Re. Walmart #835.275 located at: 400 Eubank Blvd NE – PR2

The scope of work for this Administrative Amendment re\view is the for updating of the previous AA#-**SI-2022-00847** for the Walmart building/site signage along with the gas canopy & building to the new updated font and new branding signage.

WALMART STORES, INC. STORE NO. 0835-275	06/02/22
PROJECT: ALBUQUERQUE, NM	PLAN REVISION #2
PROJECT NO. 21694016

Description: This Plan Revision consists of Drawing Sheets **A2 and A2.1** dated **06/02/22**. No specification changes.

SHEET A2.1 – EXTERIOR SIGNAGE

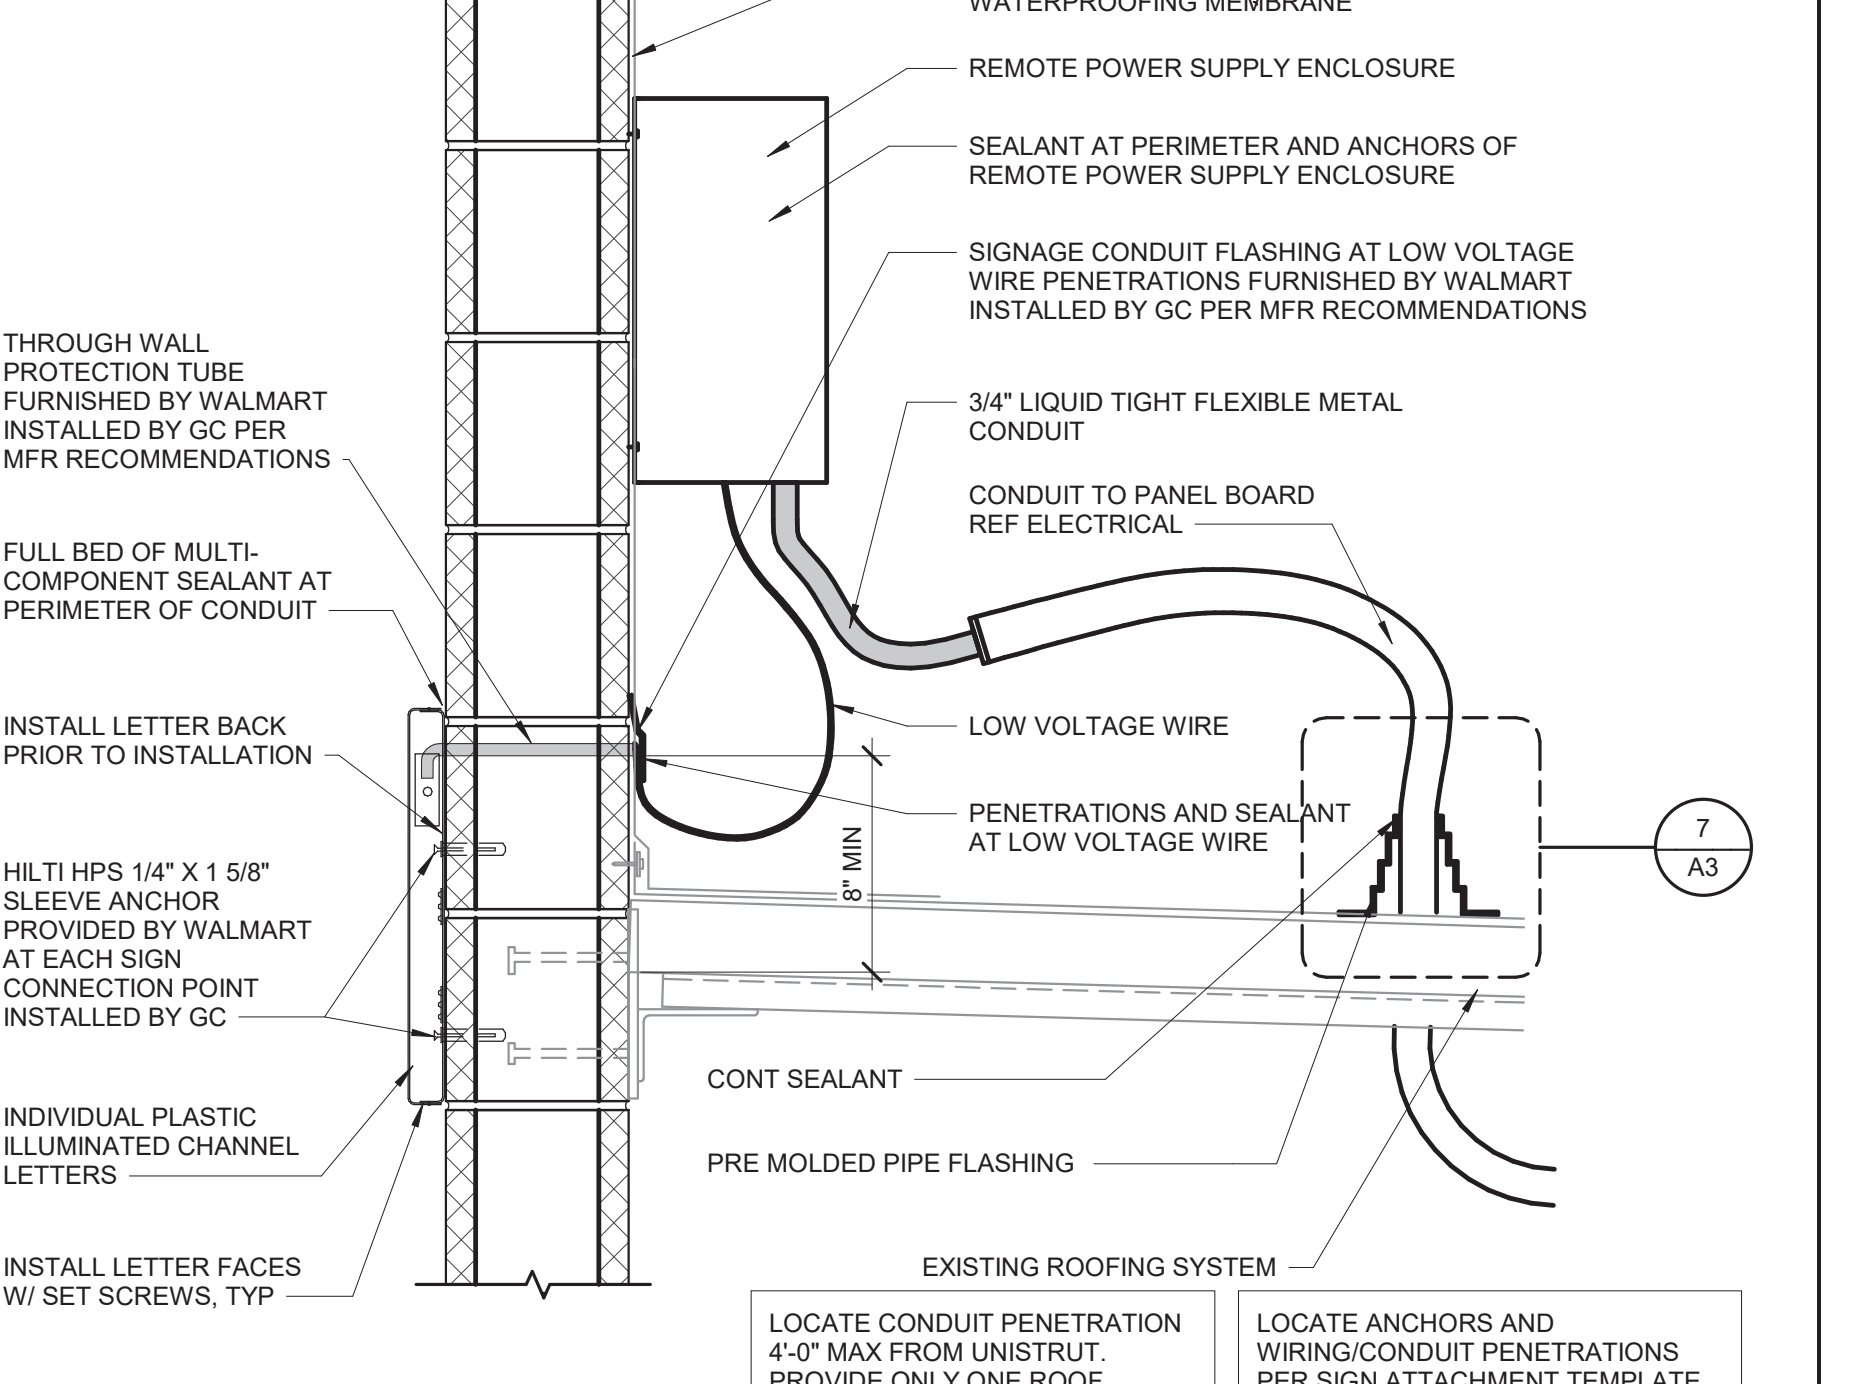
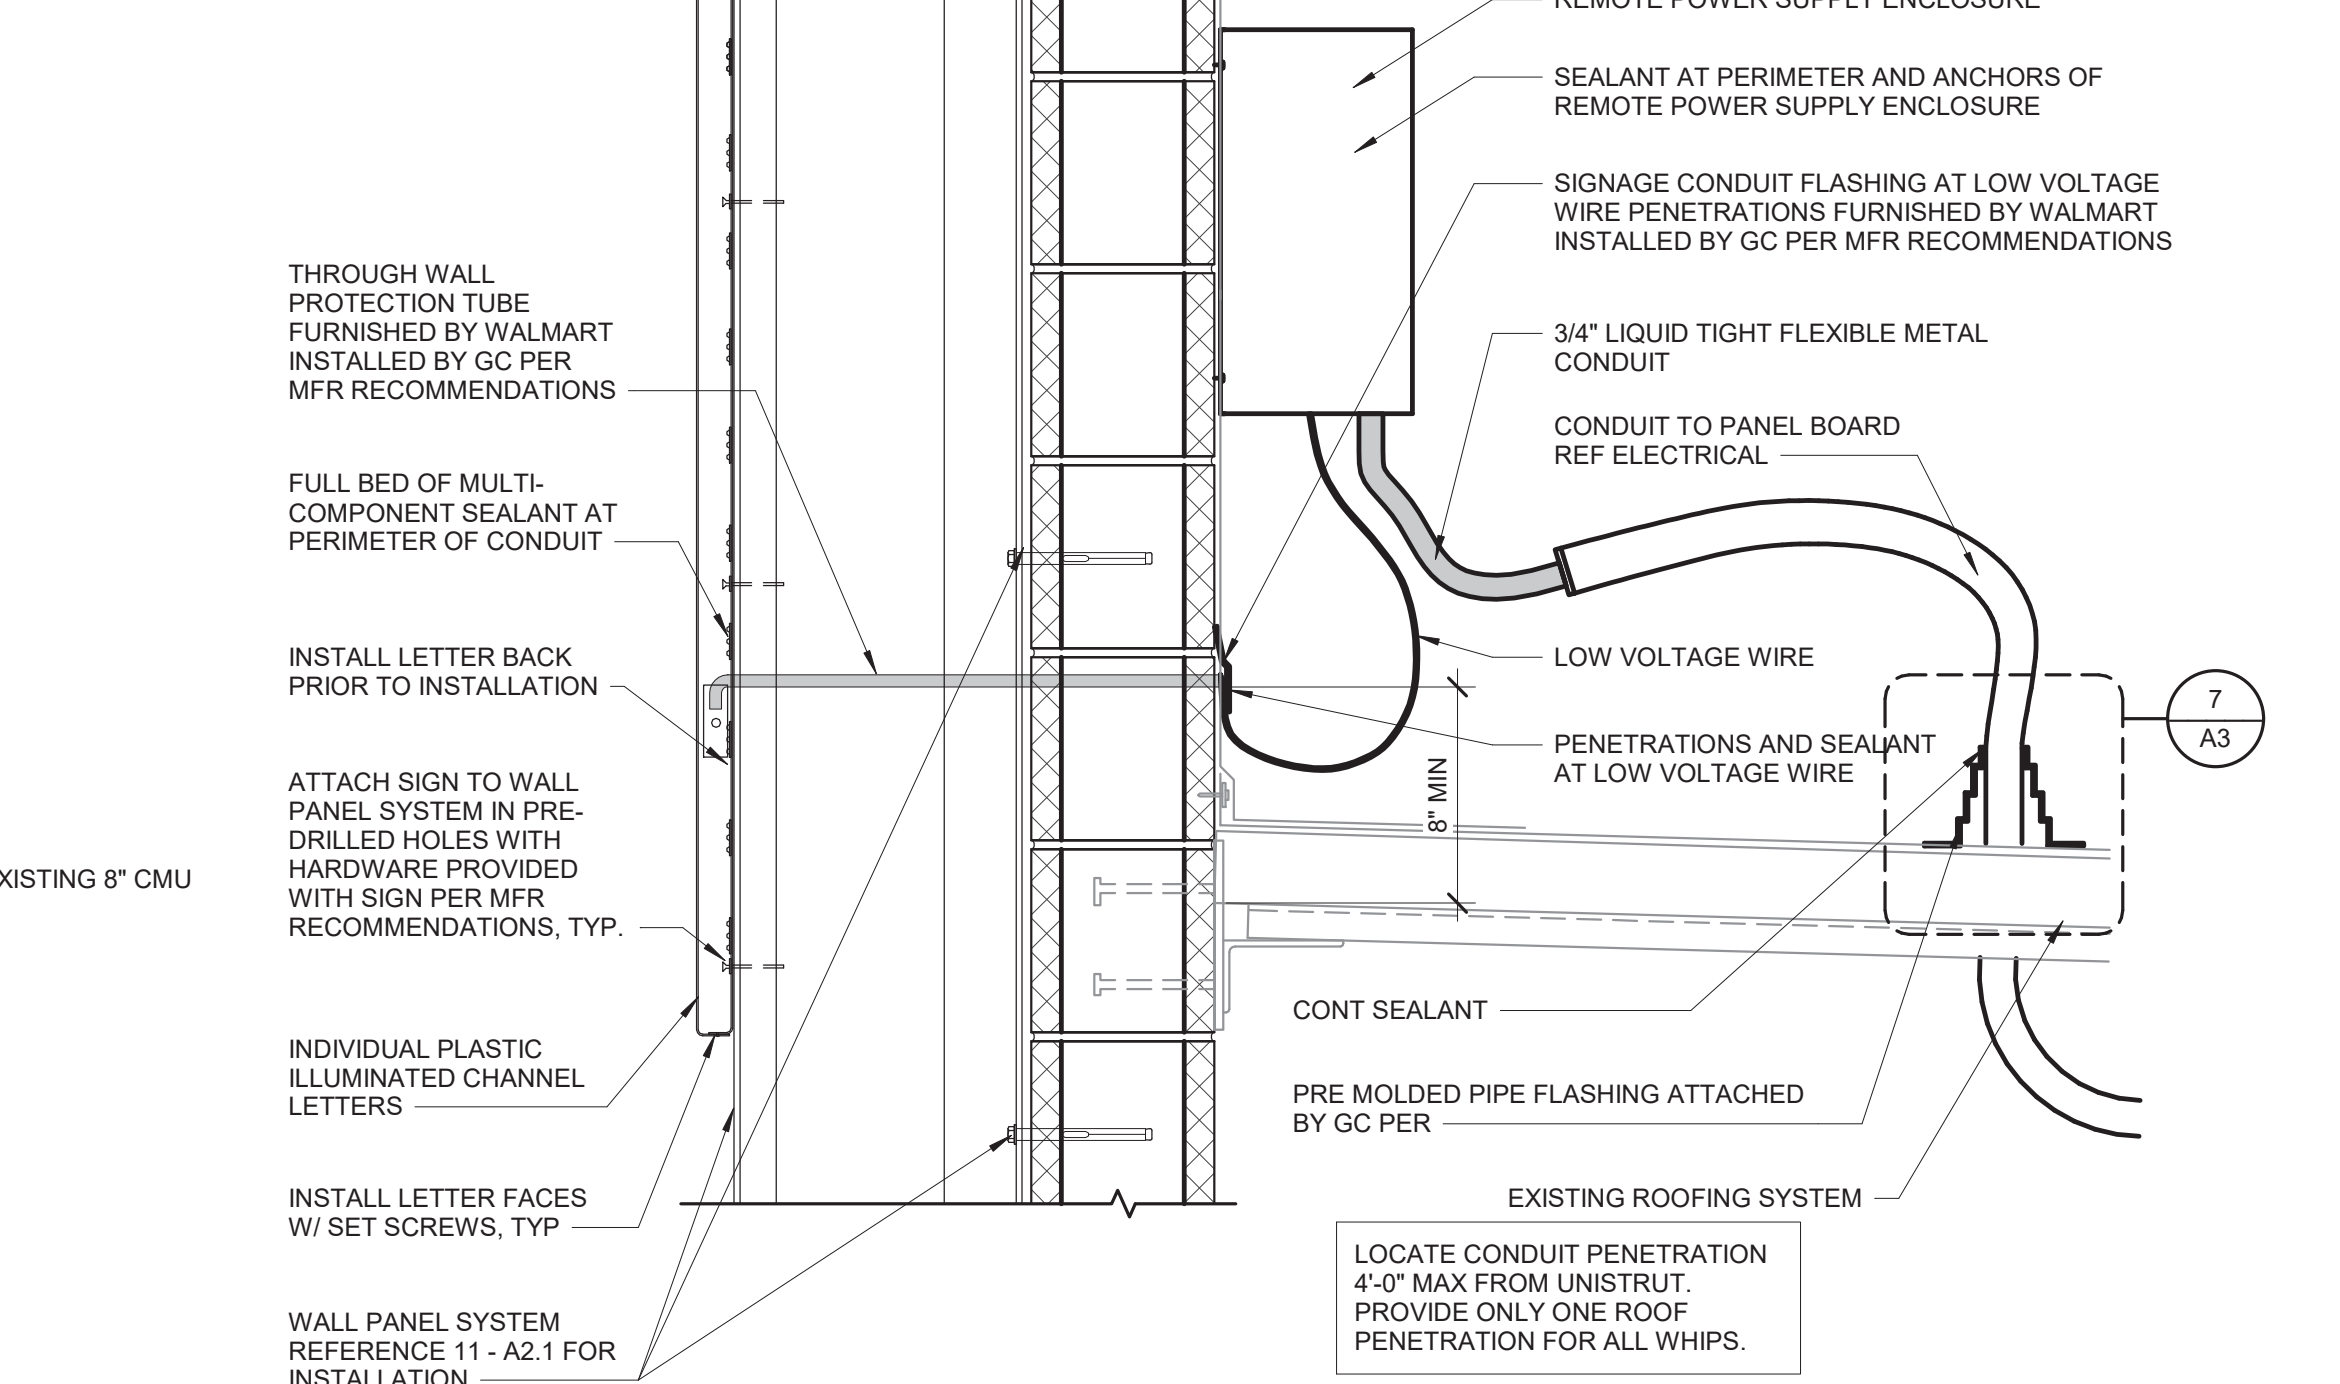
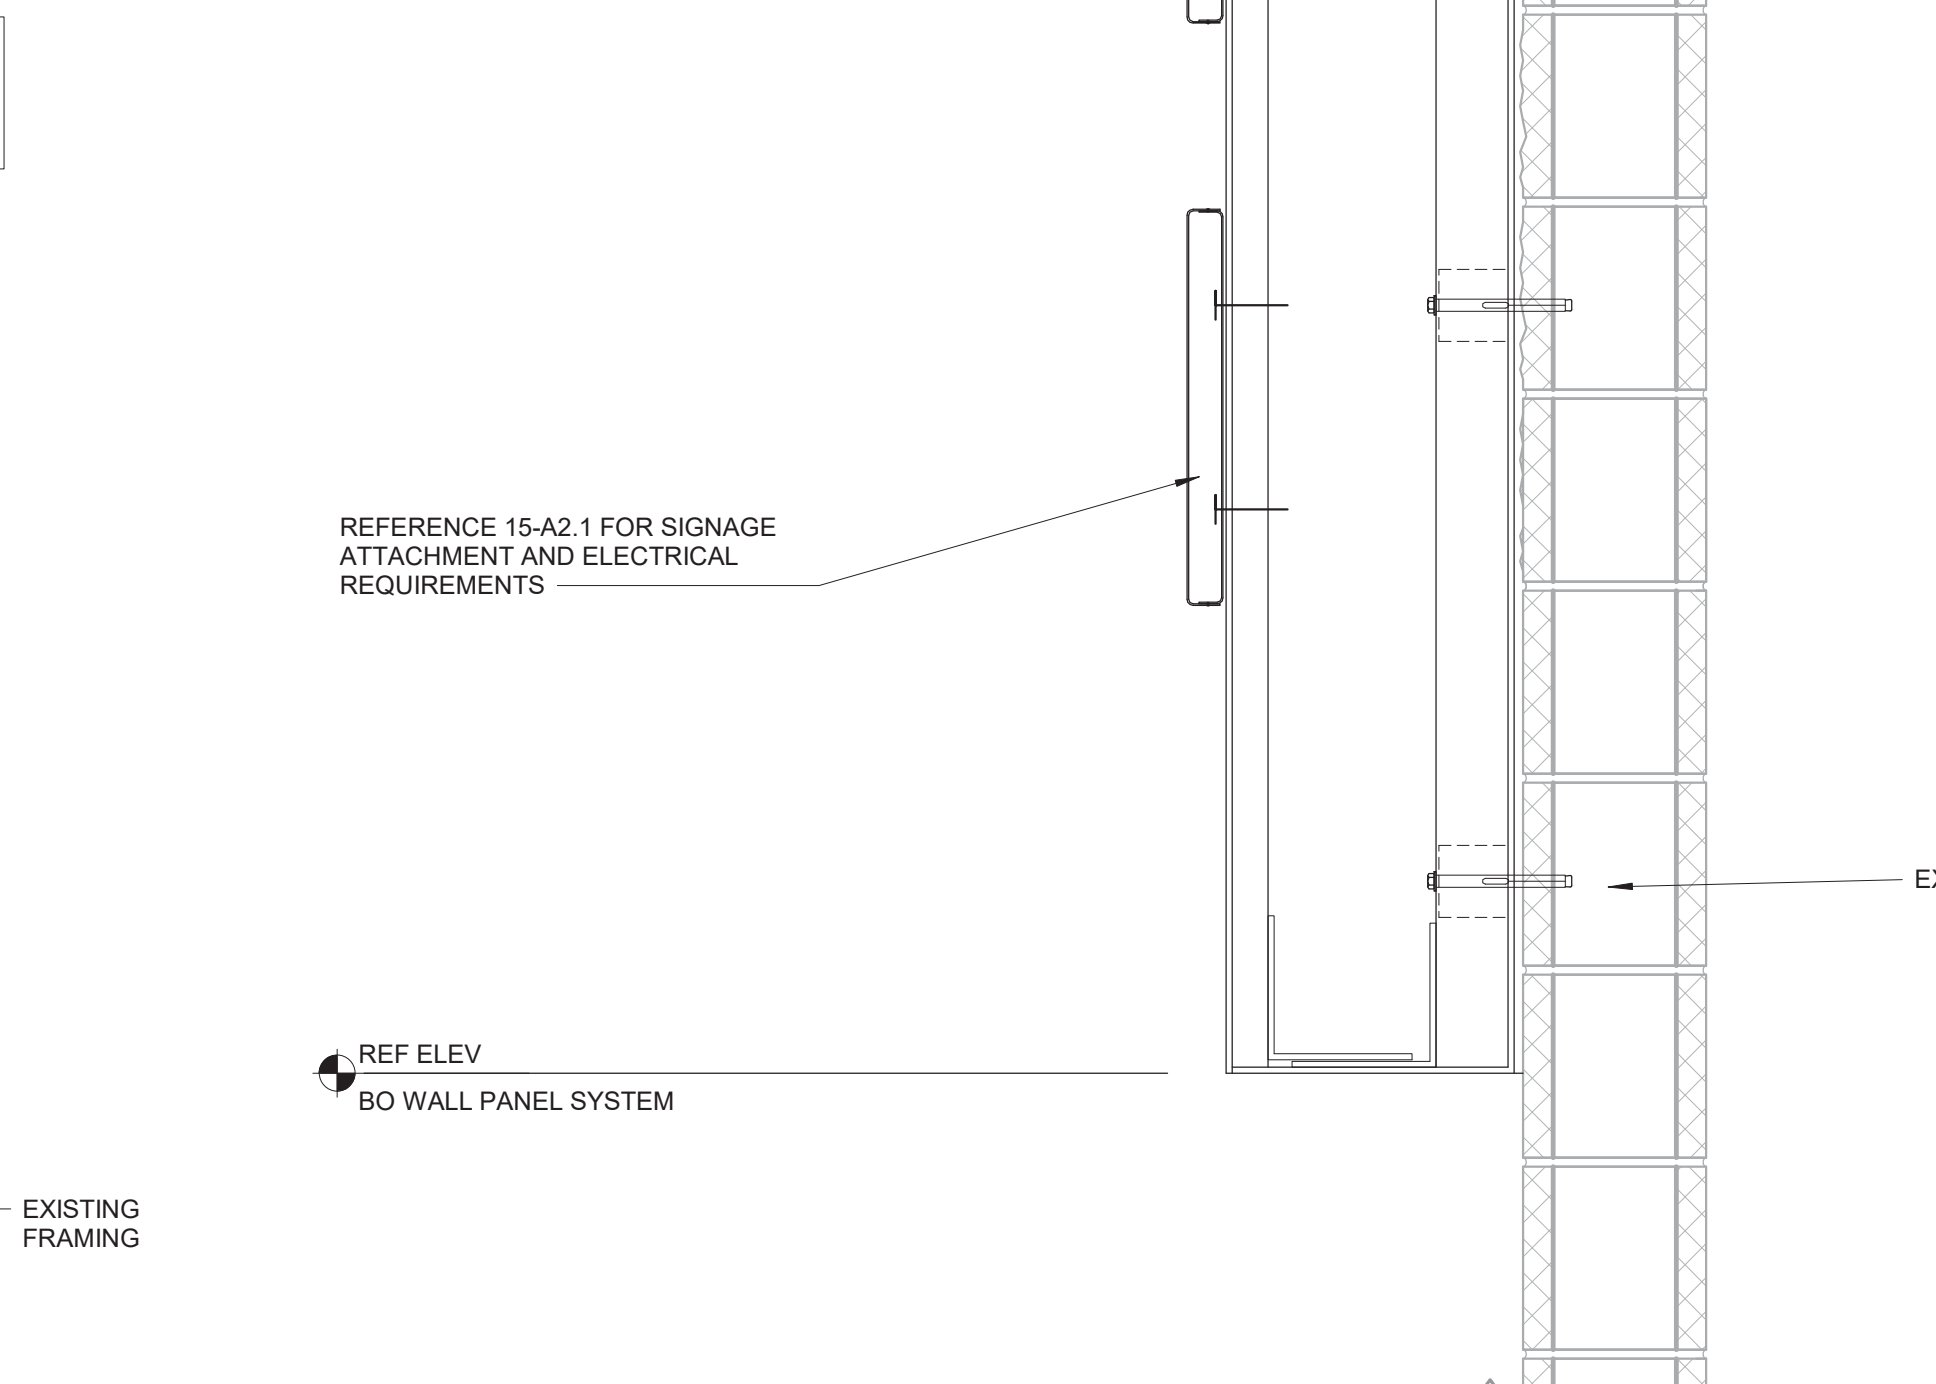
DETAIL 6 – 2'-0" SIGNAGE

1. Revise detail title from "2'-6" SGIANGE" to "2'-6" SIGNAGE". **(CI1)**
2. Revise Outdoor sign with associated notes from 2'-0" to 2'-6". **(CI1)**

DETAIL 11 – WALL PANEL SECTION (V1)

1. Revise section to reflect proper elevation for bolt on sign aligning with existing wall height. **(C11)**

NEW SIGNAGE SCHEDULE

1. Revise Outdoor sign size to 2'-0". **(C11)**

EXISTING SIGNAGE SCHEDULE

1. Revise all information to correspond with current existing conditions. **(C11)**
